Consultation Response from KC Landscape

Application No:	2023/91491
Proposed Development:	Erection of 61 age-restricted apartments with ancillary accommodation including separate residents lounge and manager facilities and associated external works, including the erection of access bridge and riverside walk featuring two pedestrian bridges (within a Conservation Area)
Location:	Prickleden Mills, Woodhead Road, Holmfirth, HD9 2JU
Applicant/Agent:	Acumen Designers & Architects Ltd
Planning Officer	Nick Hirst
Date Responded:	15.08.23
Responding Officer:	EM
Responding Ref:	MM59

Landscape Context and Concept, Landscape Design

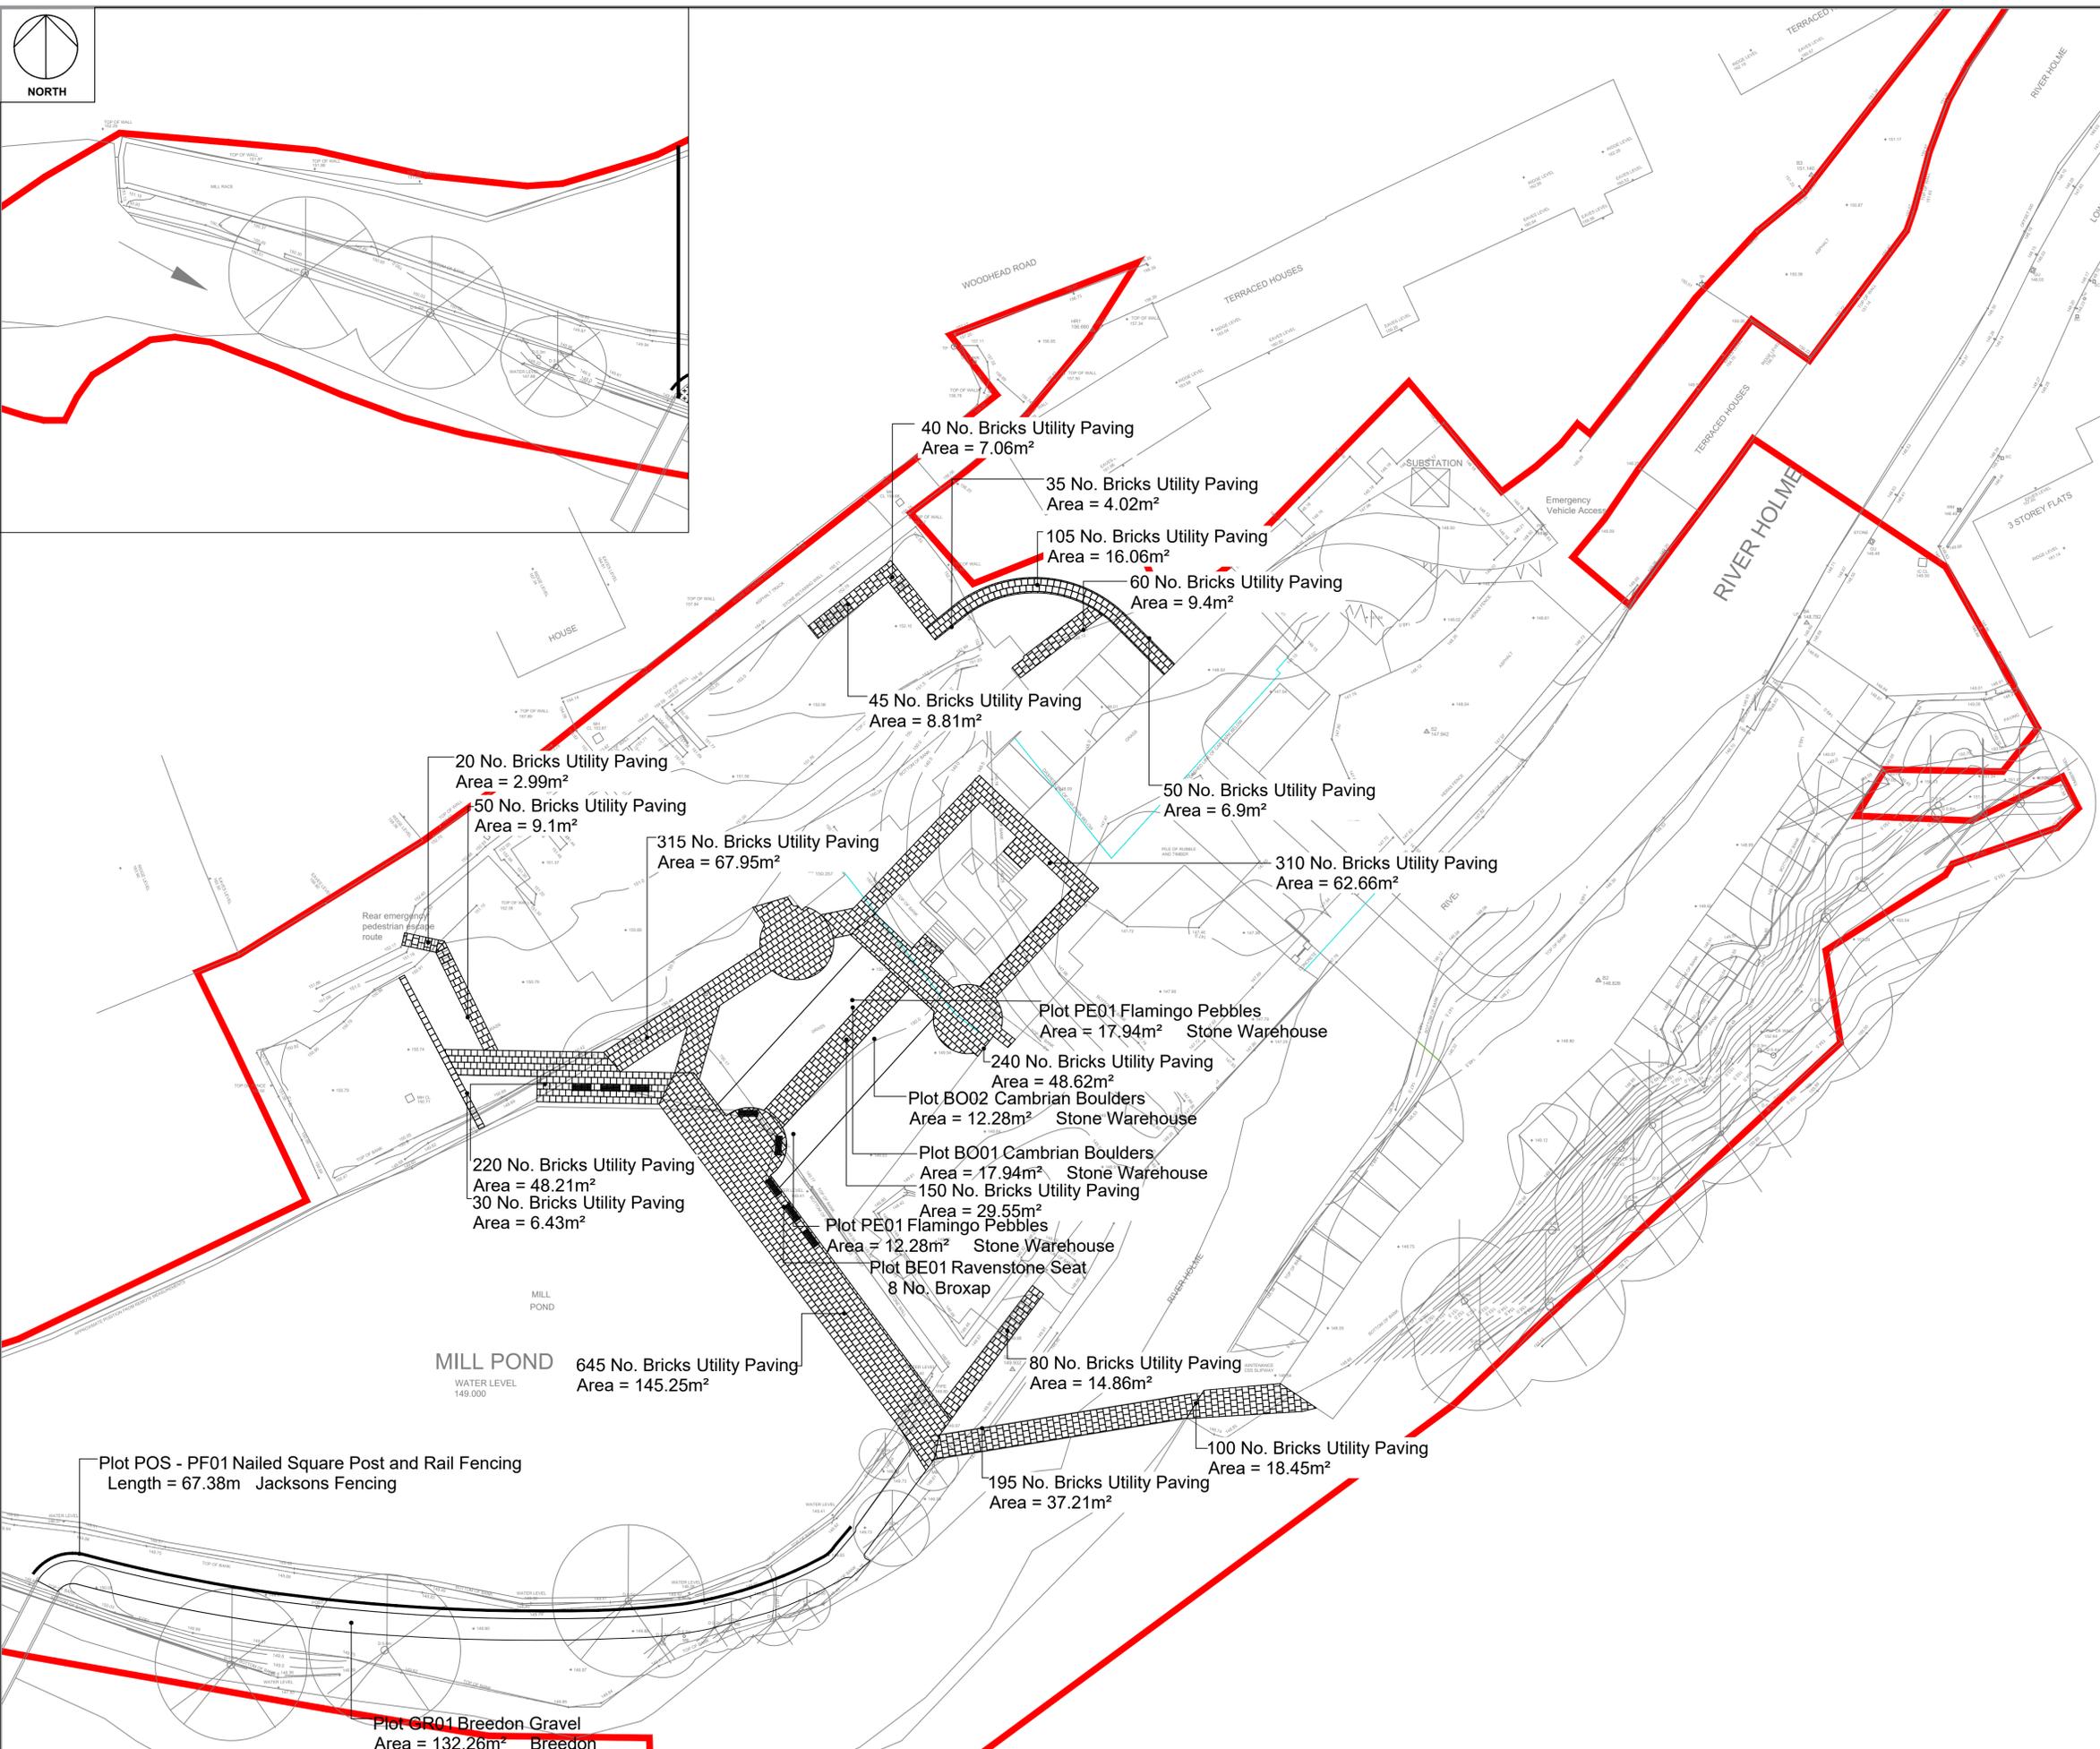
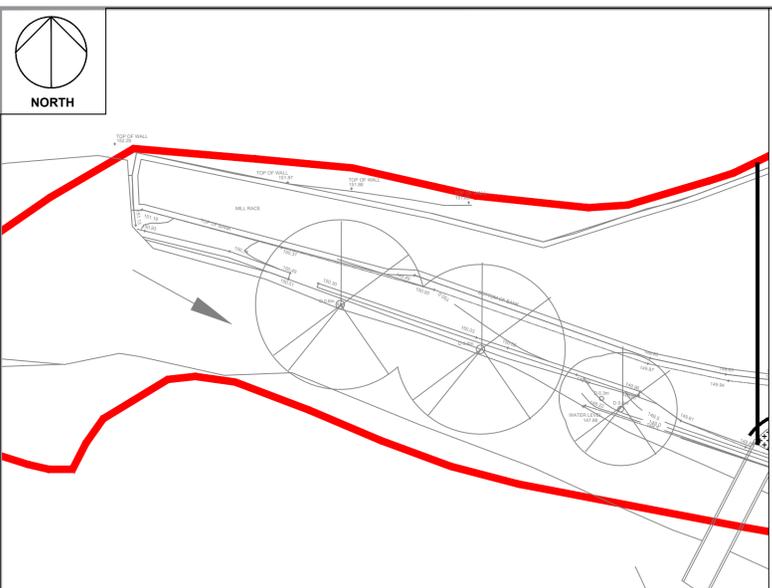
The landscape planting indicates Native Scrub mix -SCXX at a density of 4/m² proposed underneath the existing protected trees on the southern boundary. Clarification is required on how this planting will be undertaken and how the woodland and trees will be protected from harm.

Clarification details of the proposed scrub planting in the protected woodland.
